ADMINISTRATIVE AMENDMENT

A1 SITE PLAN
1" = 30'-0"

PROJECT NUMBER: PR-2021-005473
Application Number: SI-2021-00709

LADERA BUSINESS PARK UNIT 1 - CACTUS PATCH PLAZA

Drawing file: PR-2021-005473_SI-2024-01040-7801 La Morada PL NW / Revised sheets for Final approval.pdf

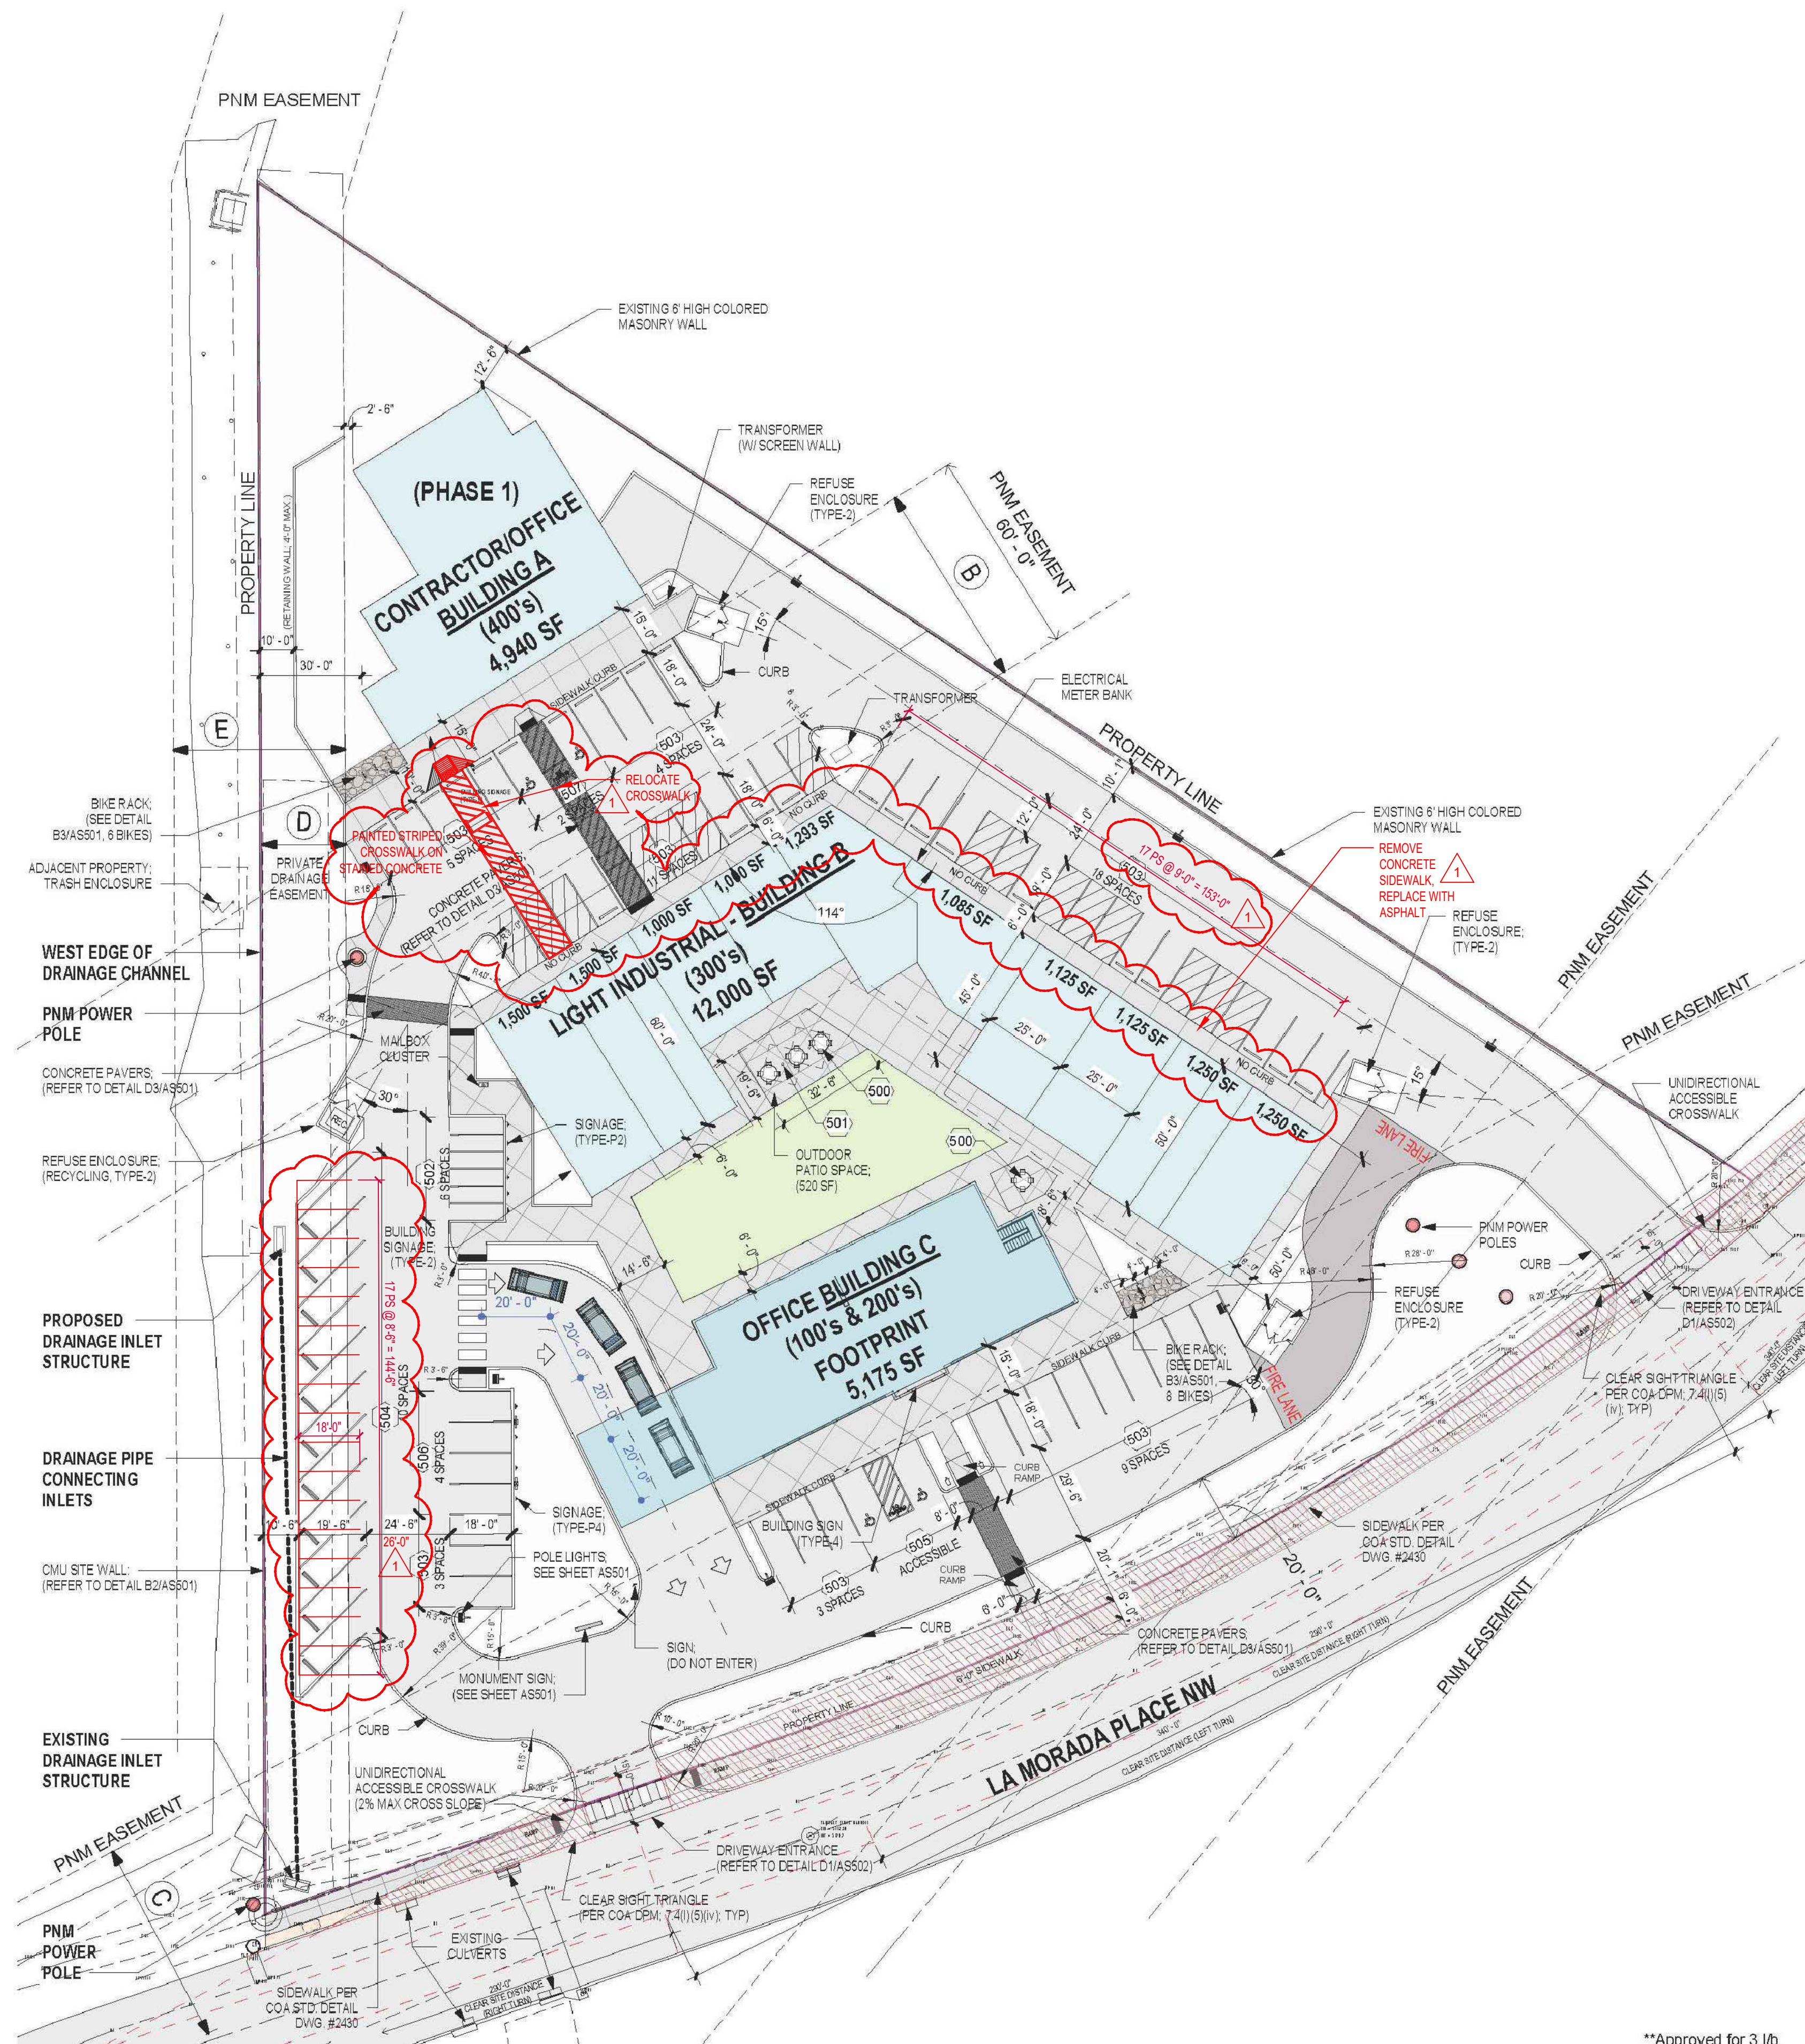
- Minor Amendment:
- Site Plan:
 - Revise parking at west site to head in and add 6 stalls.
 - Increase width of drive aisle from 24'-6" to 26'-0".
 - Adjust location of pedestrian crosswalk at north end of site and paint 4" wide strips at 45 degrees 2'-0" o.c.

- Eliminate concrete sidewalk at north and east side of building B.
 - Reduce parking stalls at east side of site from 18 to 17 to allow for actual size requirement of trash enclosure.

- Revise total parking count from 72 stalls to 77 total stalls.
 - Eliminate all phasing for project and to install landscaping.
 - Building A Elevations:

# BLDG A - EXTERIOR ELEVATIONS

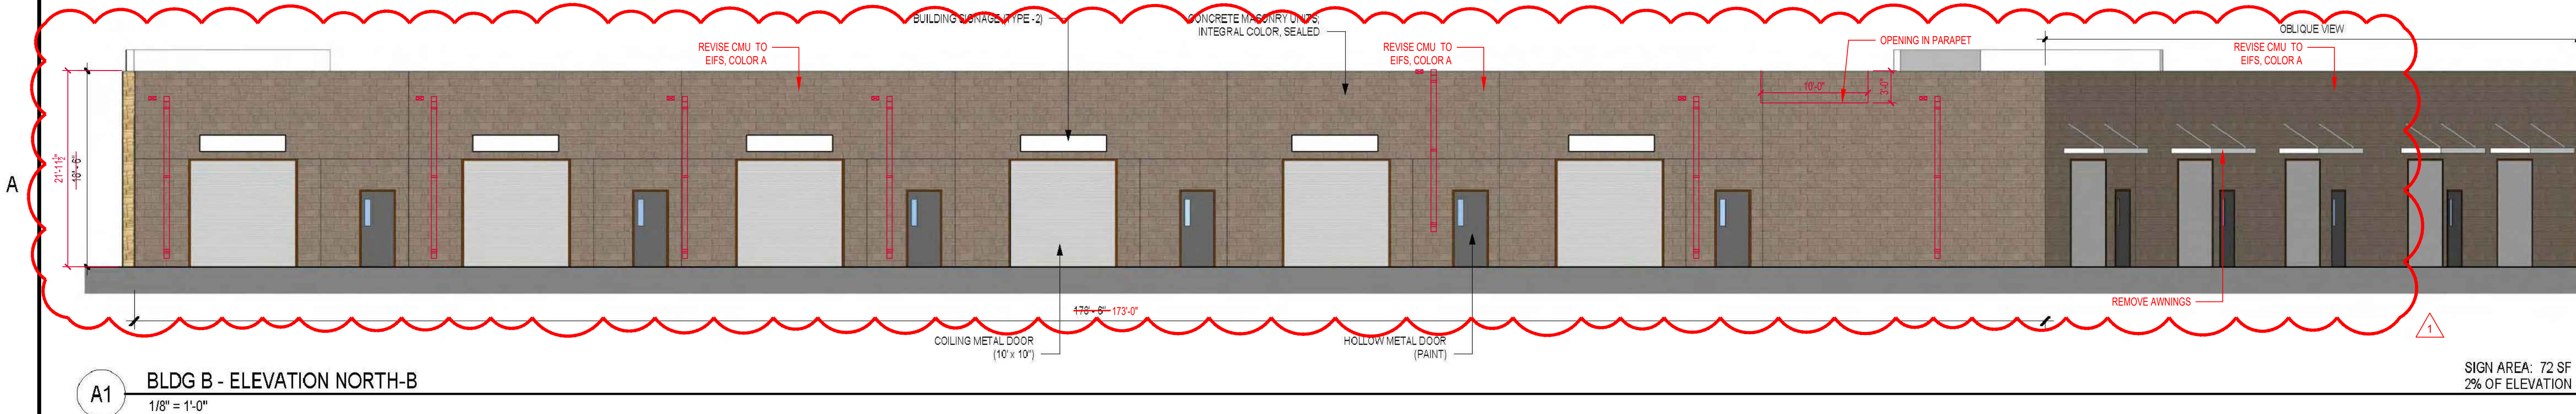
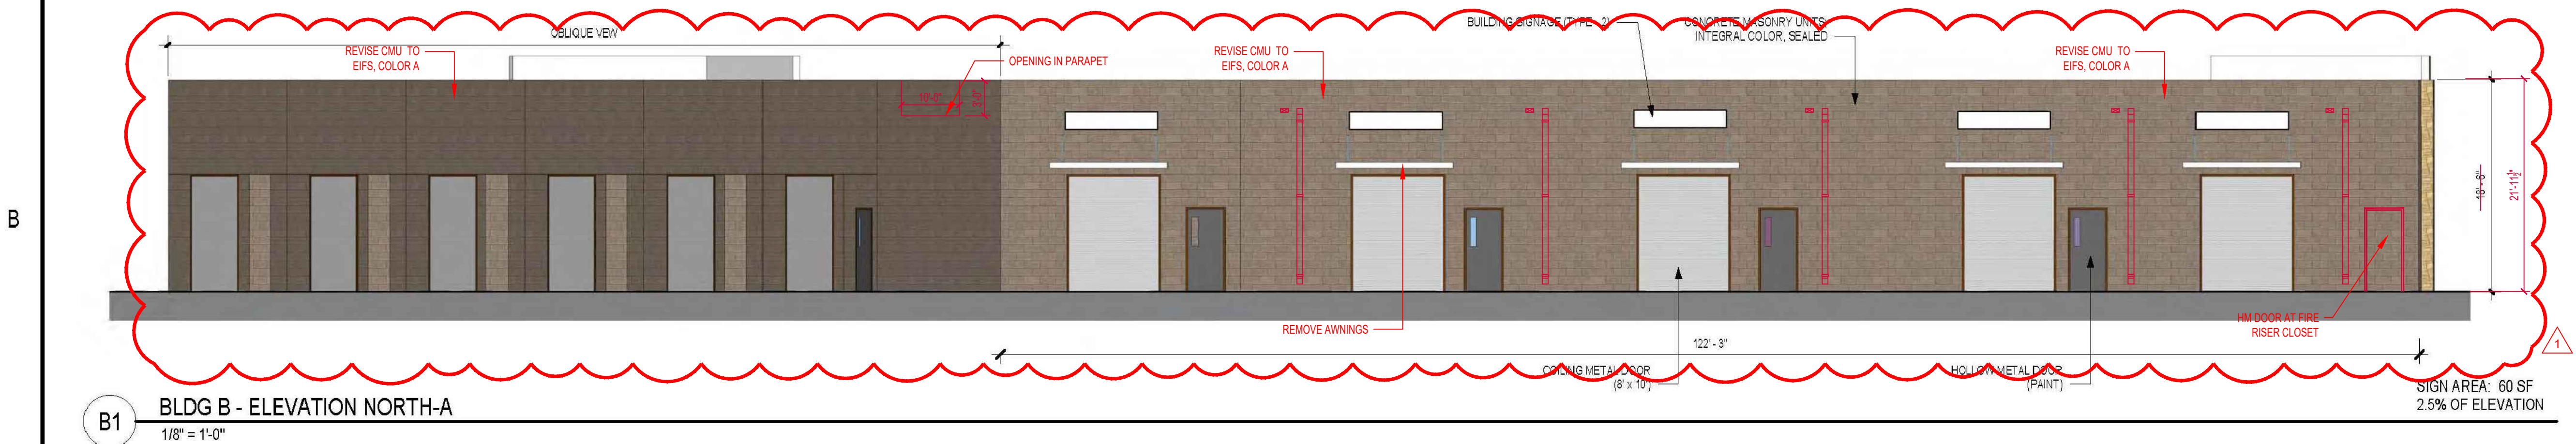
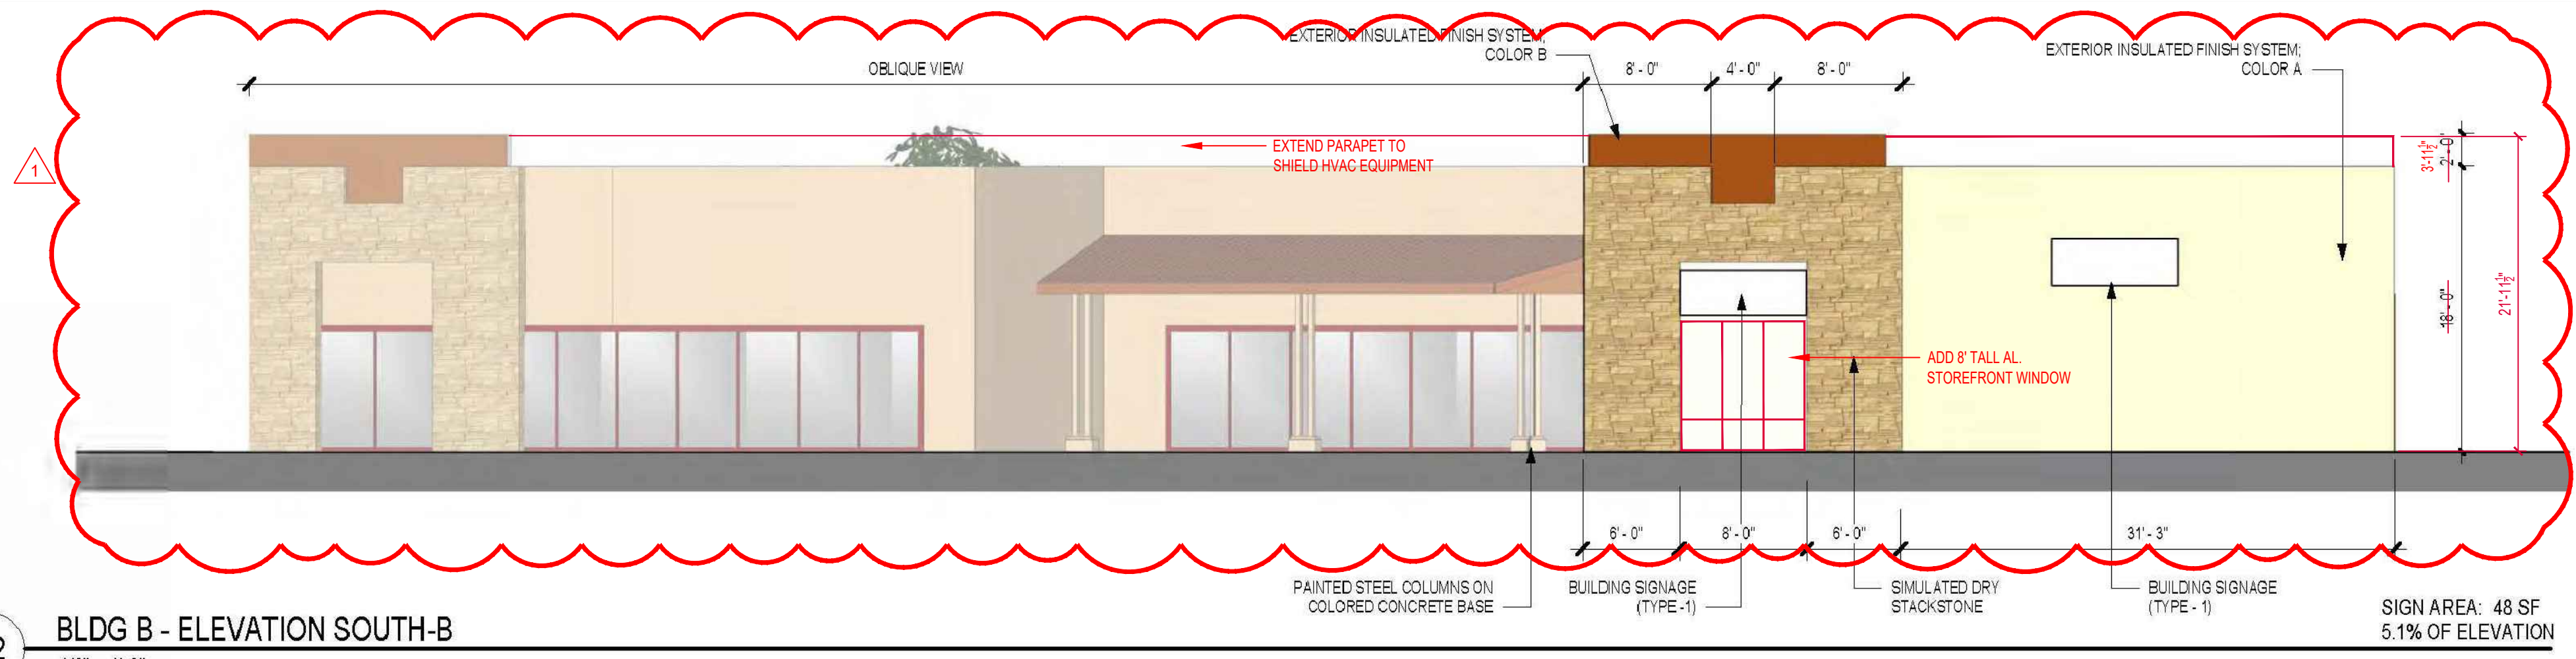
- Increase building height from 21'-0" to 23'-1" to provide HVAC screening.
 - Add 3x10' opening in parapet for access for HVAC installation to avoid overhead power lines.

## BLDG B - EXTERIOR ELEVATIONS

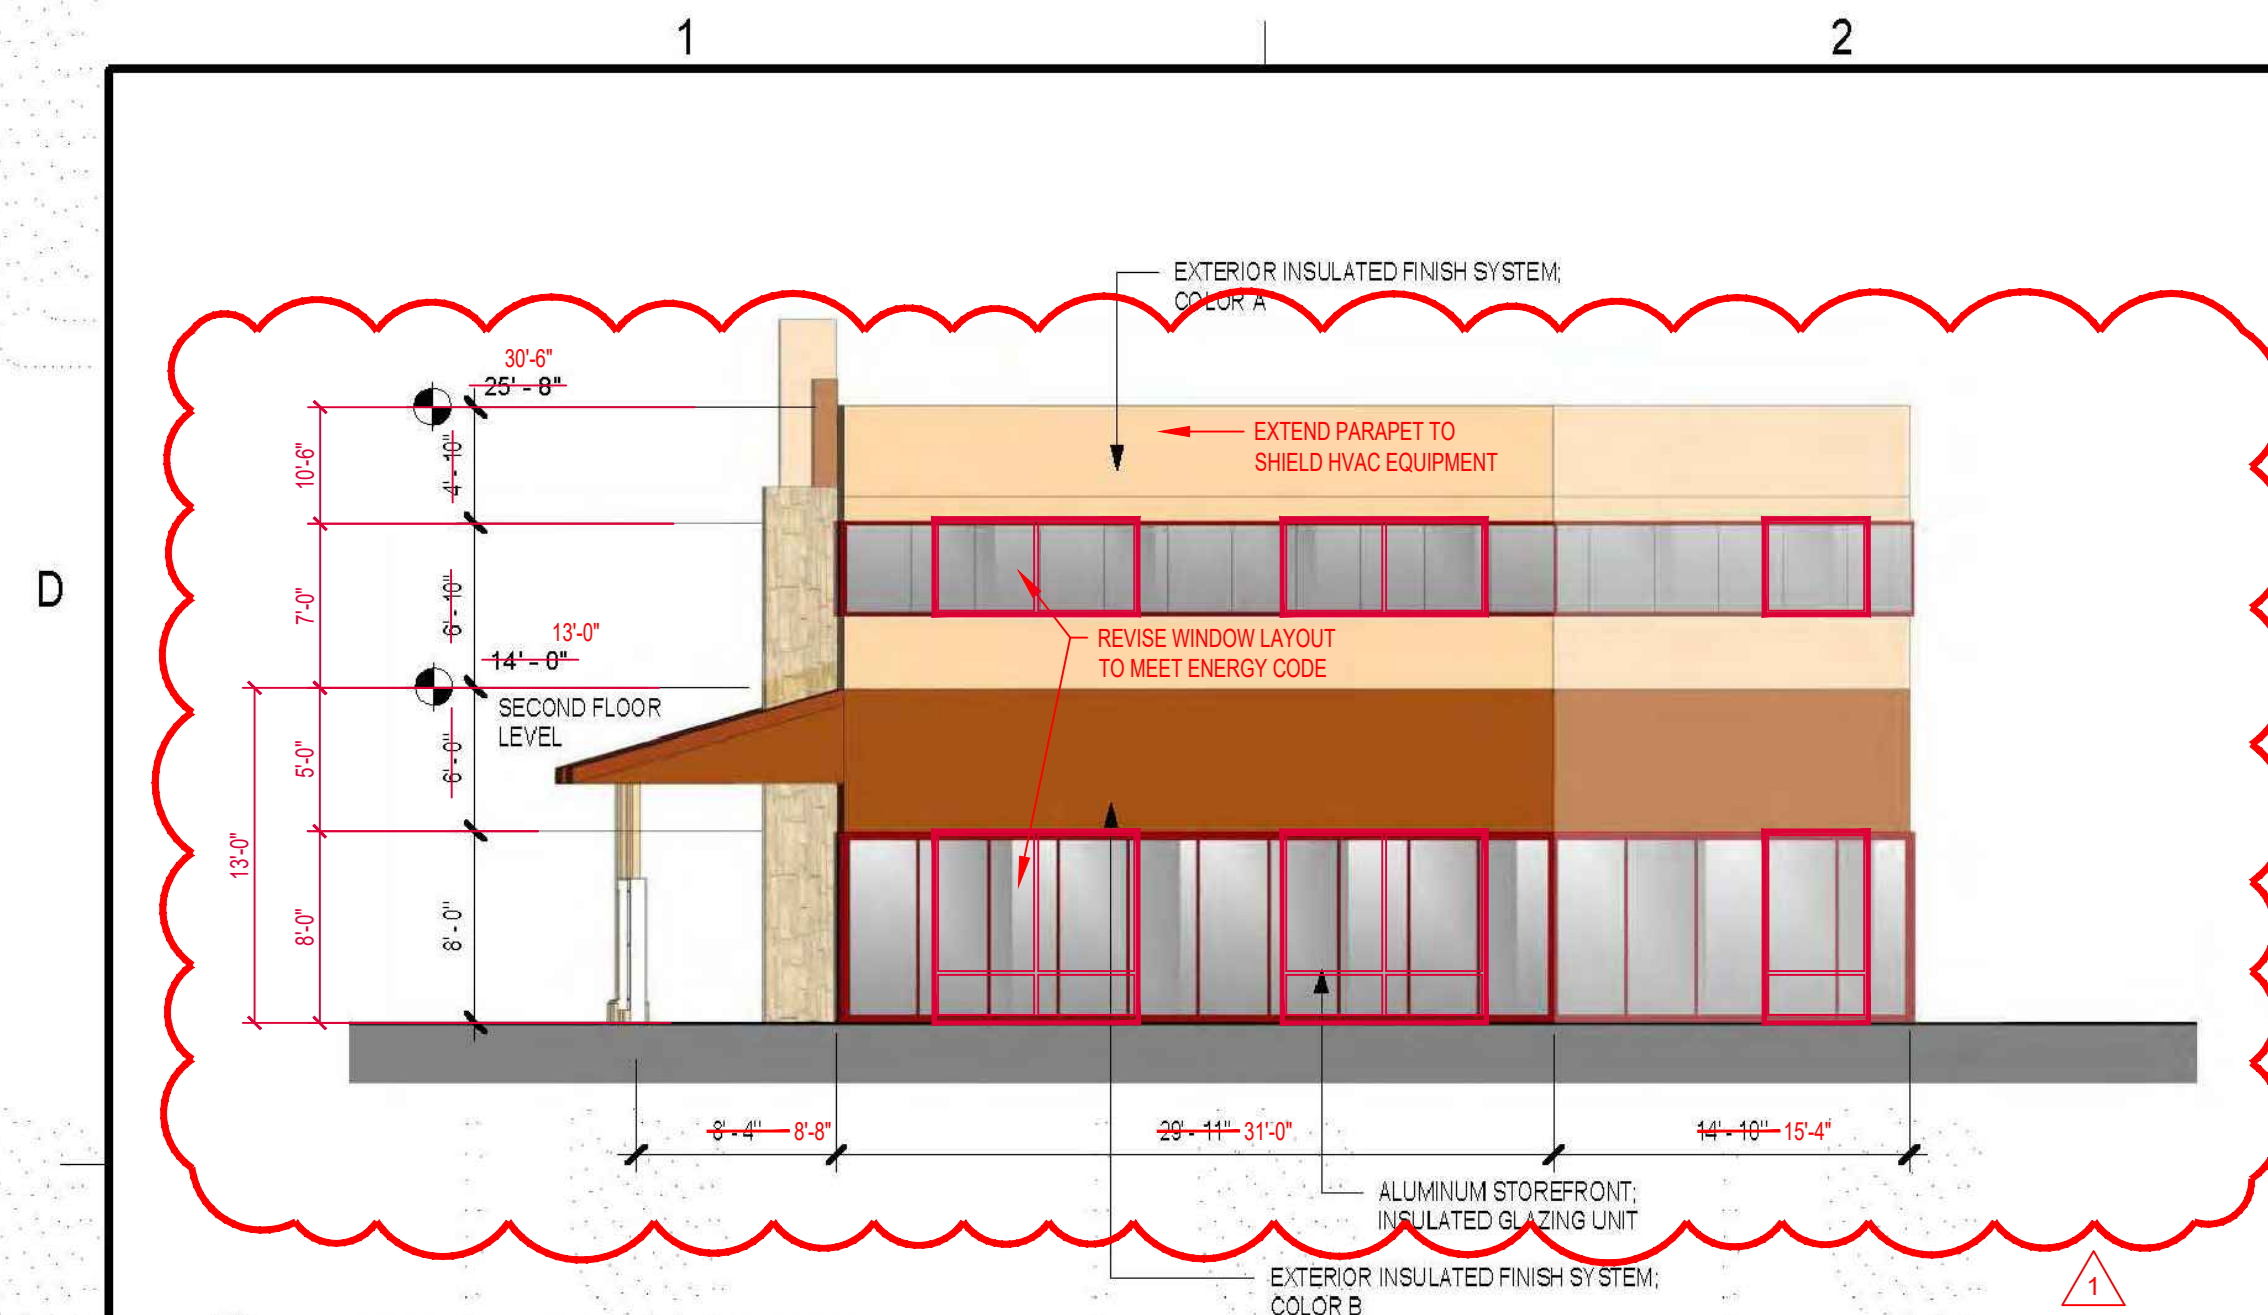
- Building B Elevations:
 - Increase building height from 20'-0" to 22'-0" to provide HVAC screening.
 - Replace CMU veneer with EIFS.
 - Remove awnings at overhead garage doors.

- Add 3x10' opening in parapet for access for HVAC installation to avoid overhead power lines.
 - Building C Elevations:
 - Increase entry tower building height from 29'-3" to 32'-0".
